Phone: 0300 123 6780
Email: lhscustomerservice@lancashire.gov.uk
Your ref:
Our ref: LHS/CS/3/2017/0245
Date: 19th April 2017

Proposal:	Proposed single storey extension to rear, shed, entrance gates, walling, landscaping and minor alterations to buildings.
Location:	Barnsteads Barn Waddington Road West Bradford BB7 4SX
Grid Ref:	374131 - 444382

Proposed Site Plan - External Works Overview Key Plan

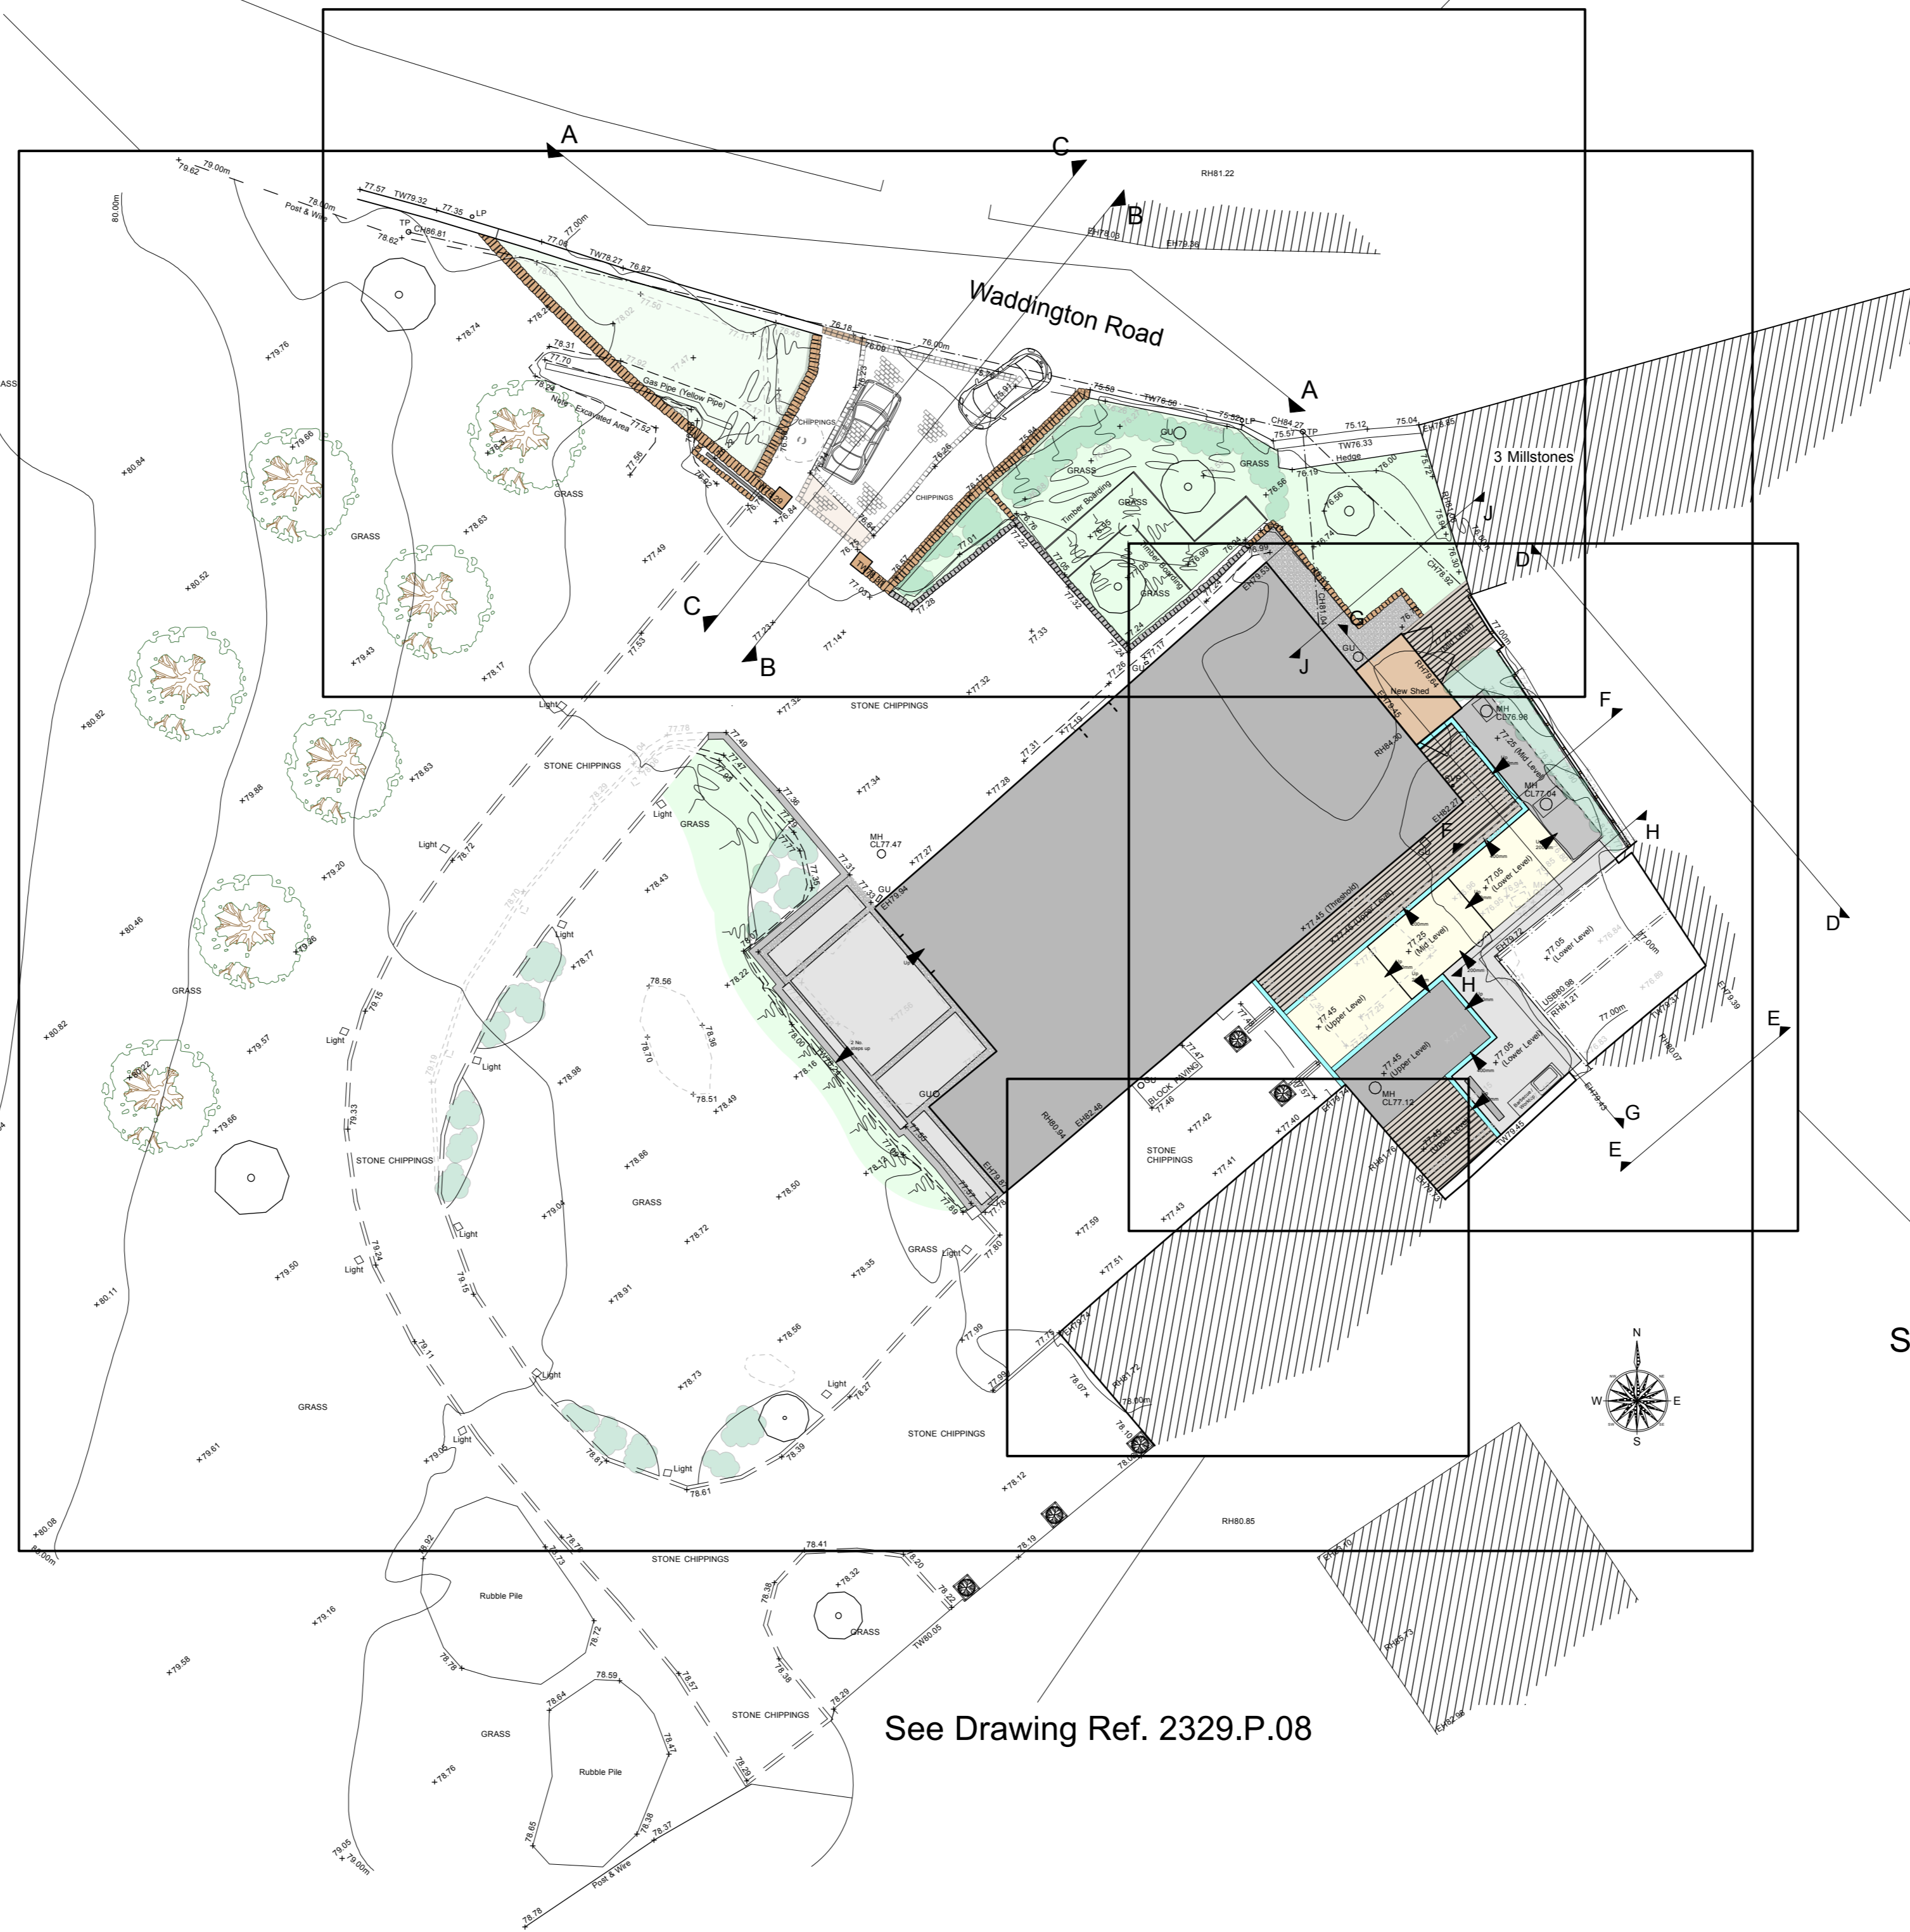
The Highway Development Control Section does not have any objections in principle to the proposed alterations, providing the sight lines at the site access can be protected. This will require the new stone wall to be no more than 1m high at the site access for a distance of 2m into the site.

1. The land within 2m of the back edge of the channel line of the carriageway of Waddington Road shall be reduced to and be permanently maintained henceforth at a height not greater than 1m above the crown level of the carriageway of Waddington Road and shall be maintained thereafter, free from obstructions such as walls, fences, trees, hedges, shrubs, ground growth or other structures within the splays in excess of 1.0 metre in height above the height at the centre line of the adjacent carriageway. Reason: To ensure adequate visibility at the street junction or site access in the interest of highway safety in accordance with Quality of Development Policy and Transport Policy in the Local Plan.
